Mr. Jim Nikkel
Meridian Ranch Fieldhouse

LSC Responses to EPC TIS Redline Comments

**Deviation Exhibit No. 2
Requested Deviations**

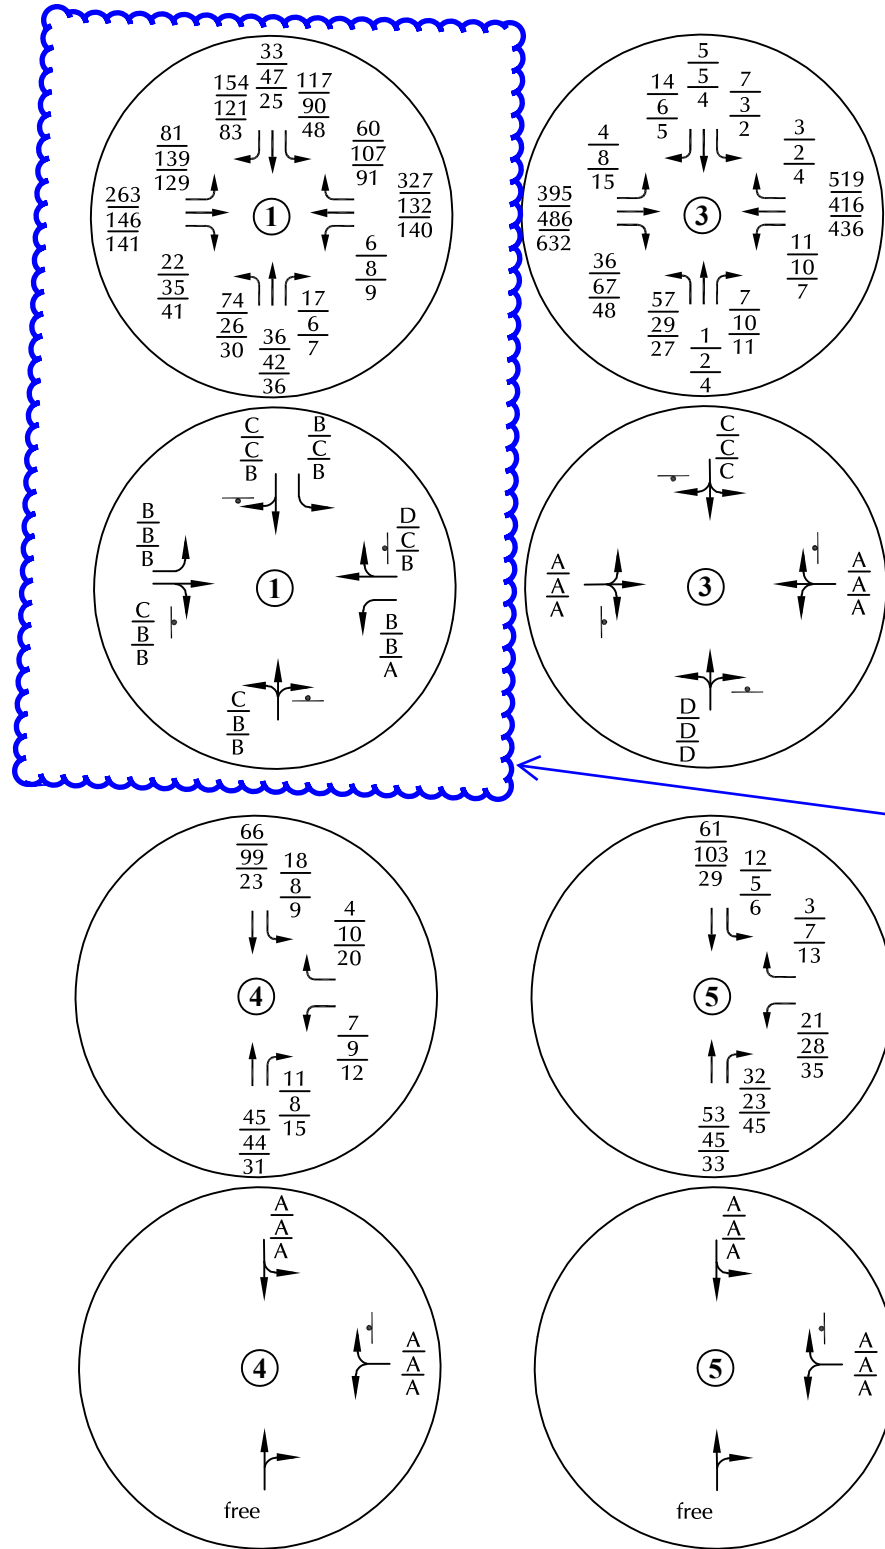
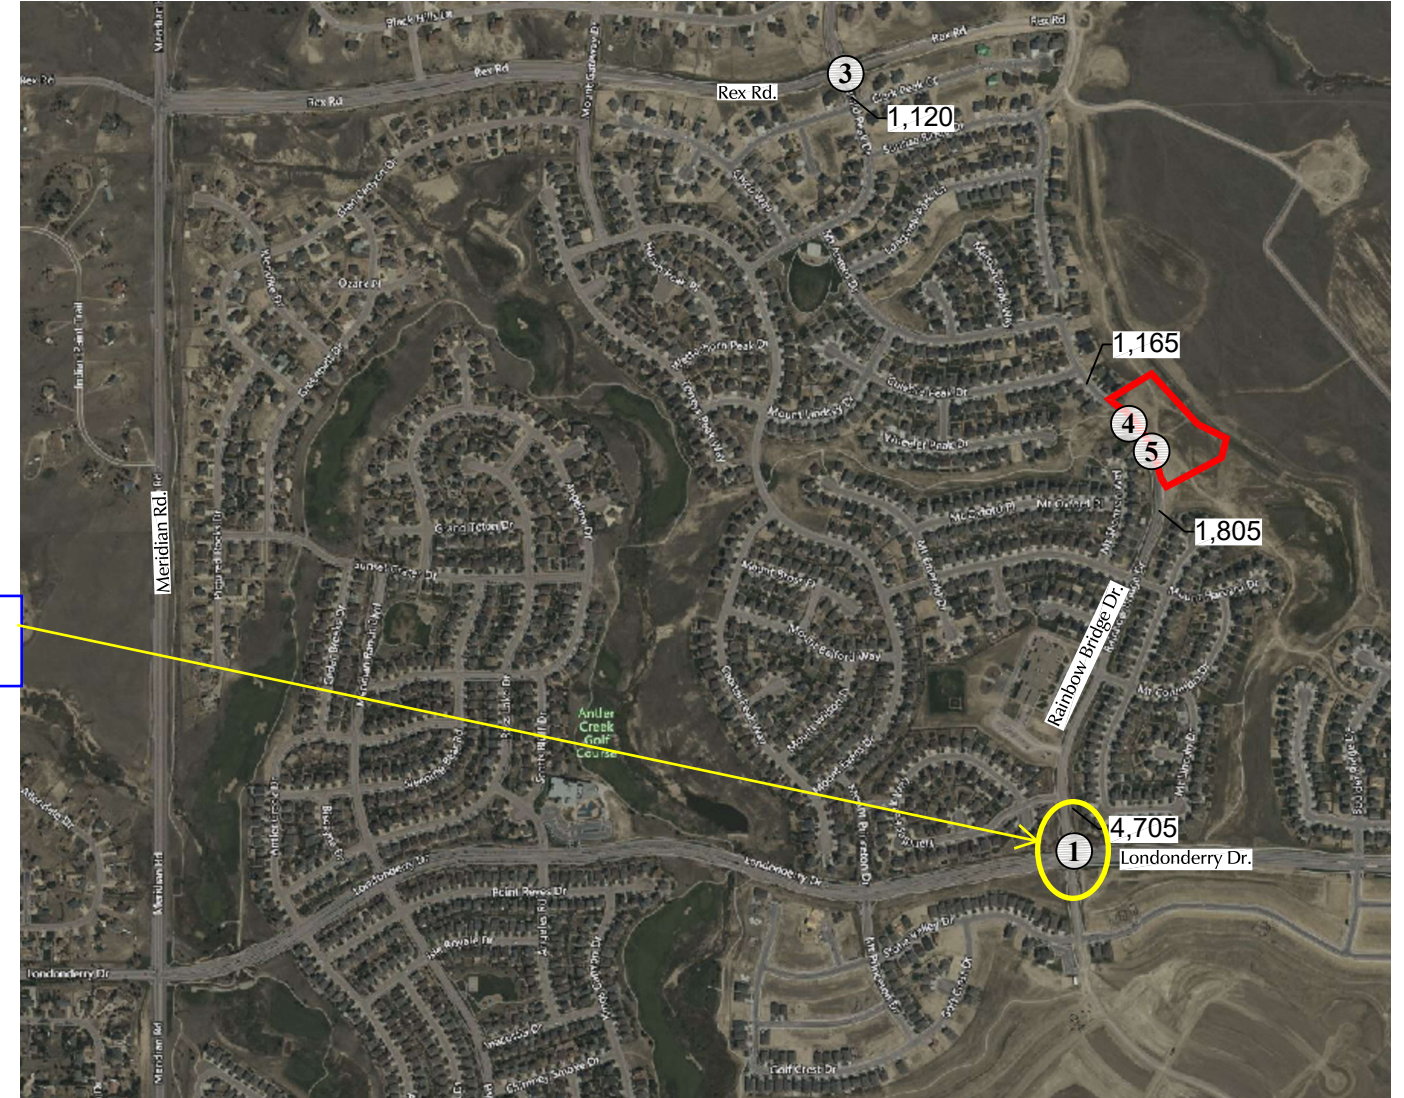
Please submit a Deviation Request for these two movements since they exceed the ECM thresholds and a non action is being recommended.

Author: Kirstin Ferrin Subject: Sticky Note Date: 7/24/2024 4:28:24 PM
LSC Response: A deviation request will be submitted.
